DECISION DELEGATED TO DEVELOPMENT MANAGER

Application No:	H02-0455-20	Applicant:	Postland Developments Ltd.
Proposal:	Proposed chalet bungalow with double garage - re-submission of H02-1202-19		
Location:	Land Between 44-46 Postland Road Crowland		
Terminal Date:	6th September 2020

Project PLOT 8,POSTLAND ROAD CROWLAND				Aspect Architectural Design
Title PLOT 8 FLOOR PLANS & ELEVATIONS				
29A Church Street Northborough Peterborough PE6 9BN Telephone 07907030047				
Scale 1:100	Date Nov 19	Job No 219	© Copyright	
Category D	CisB Element (--)	Sequential No 03	Revisions A

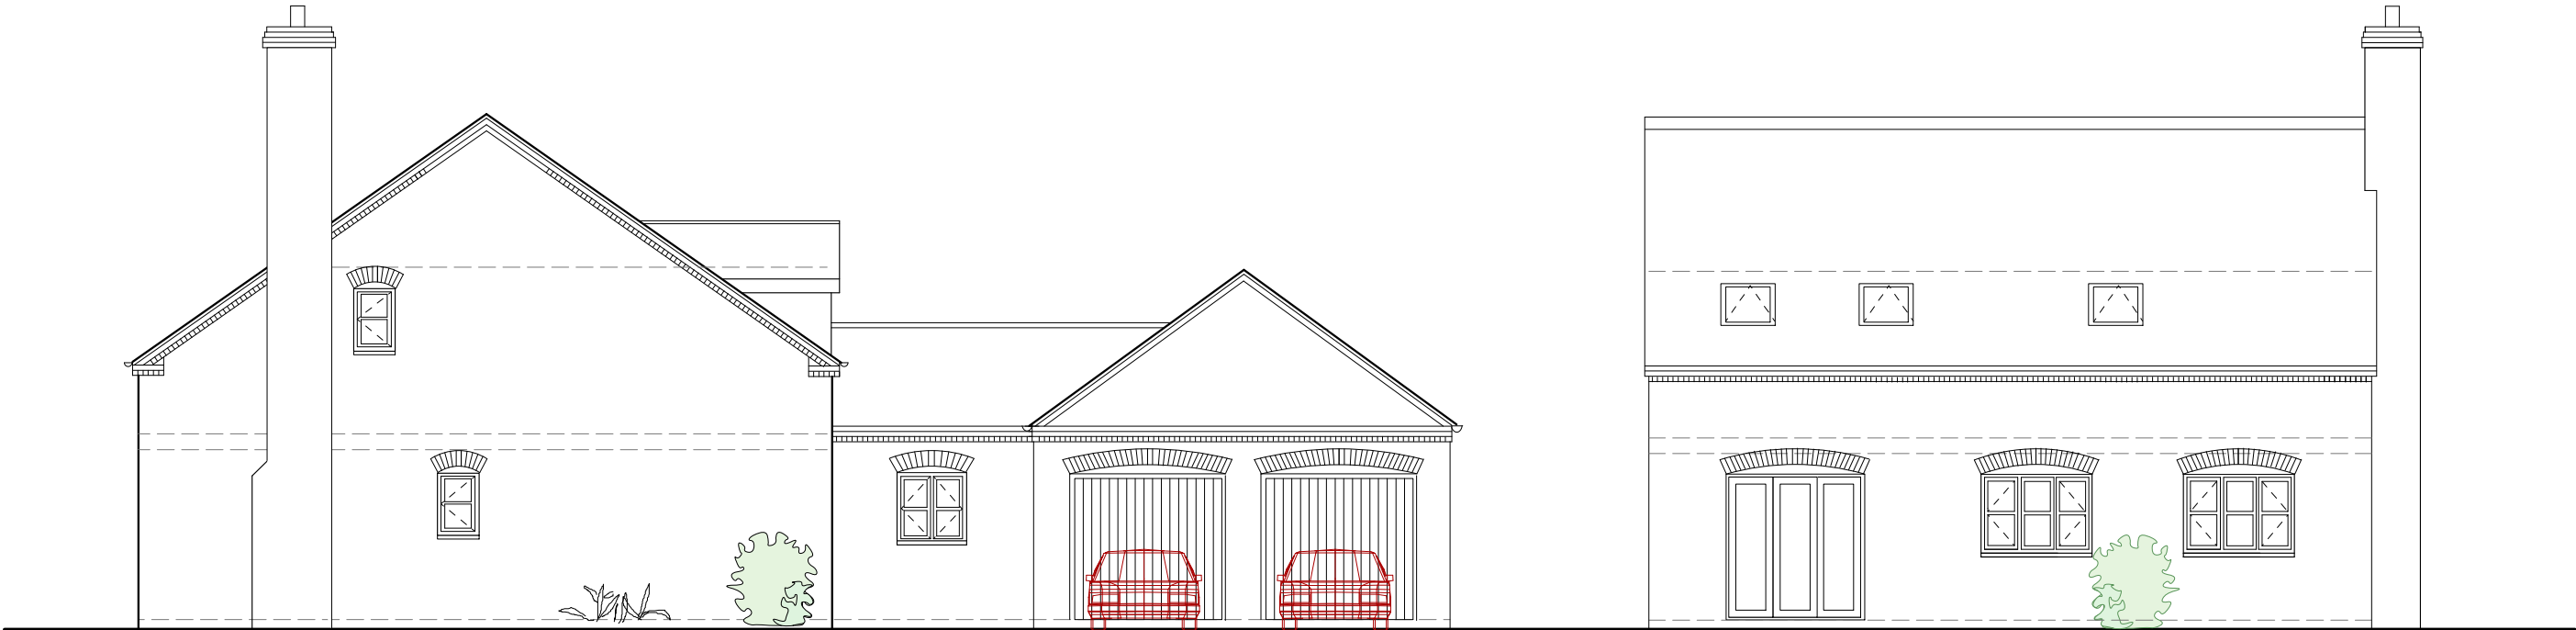
There is not considered to be a material impact on the character of the area. Dwellings in the vicinity are of varying ages and design. The fenestration and height of the building minimises potential for overlooking and overshadowing to neighbouring properties.

90 sqm floor area
GROUND FLOOR PLAN

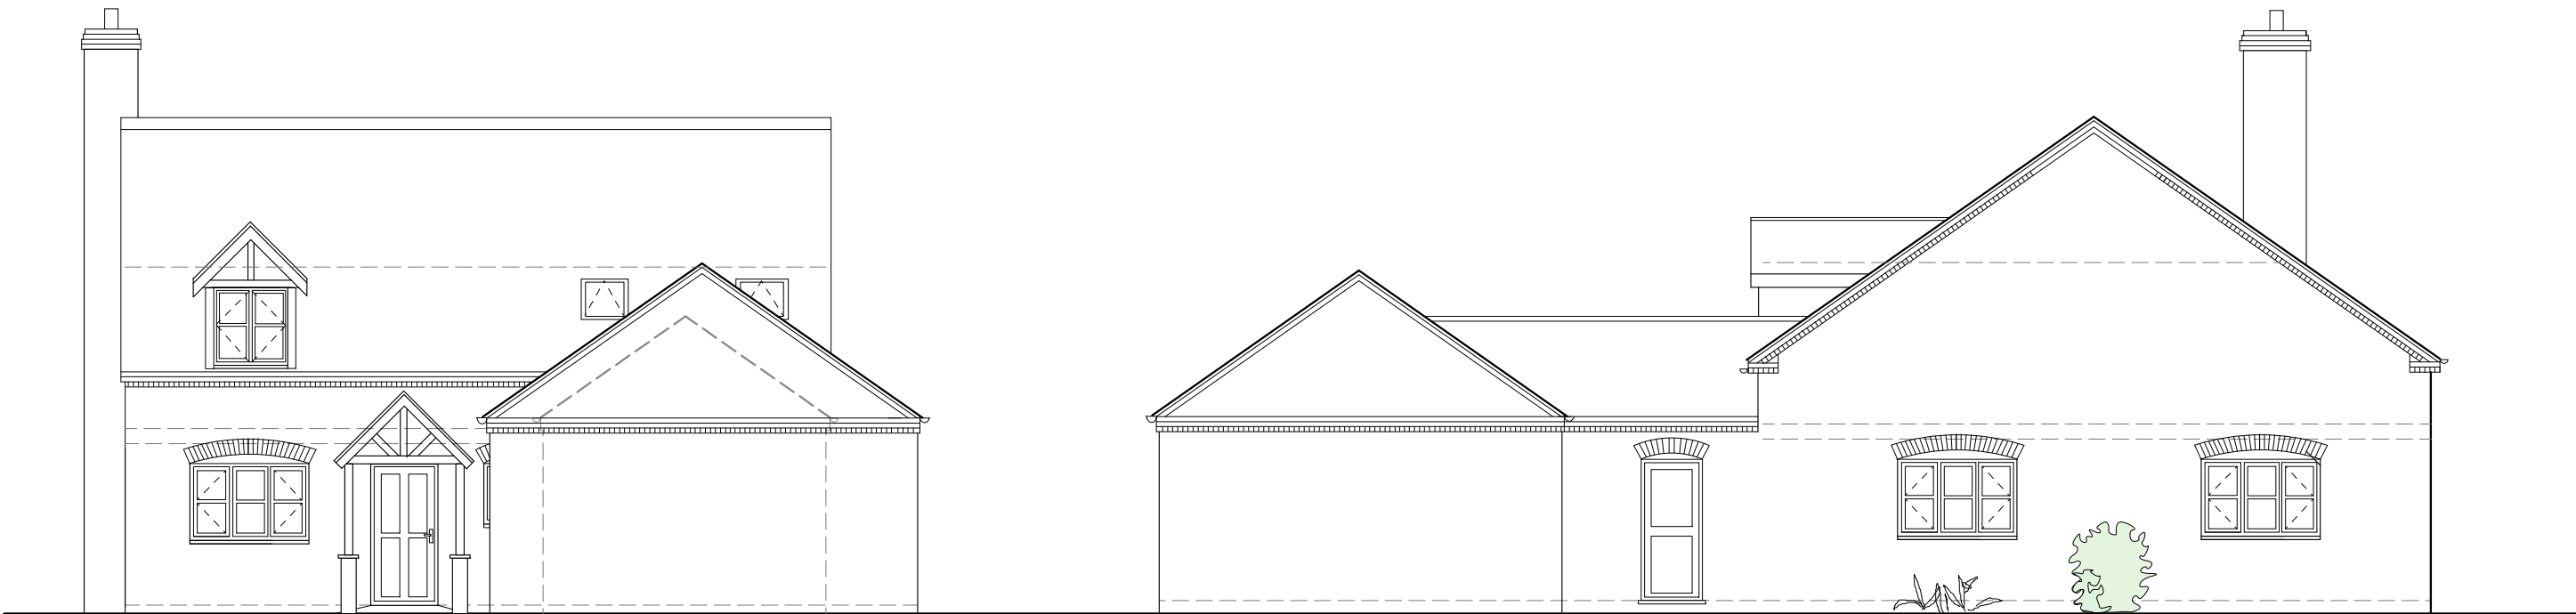
In terms of the first element, the proposal will provide wider sustainability benefits to the community that outweigh flood risk; that is, the provision of additional housing a sustainable location within the district. In terms of the latter, the submitted details show that the new finished floor levels of the dwelling are to be sited 500mm above ground level.
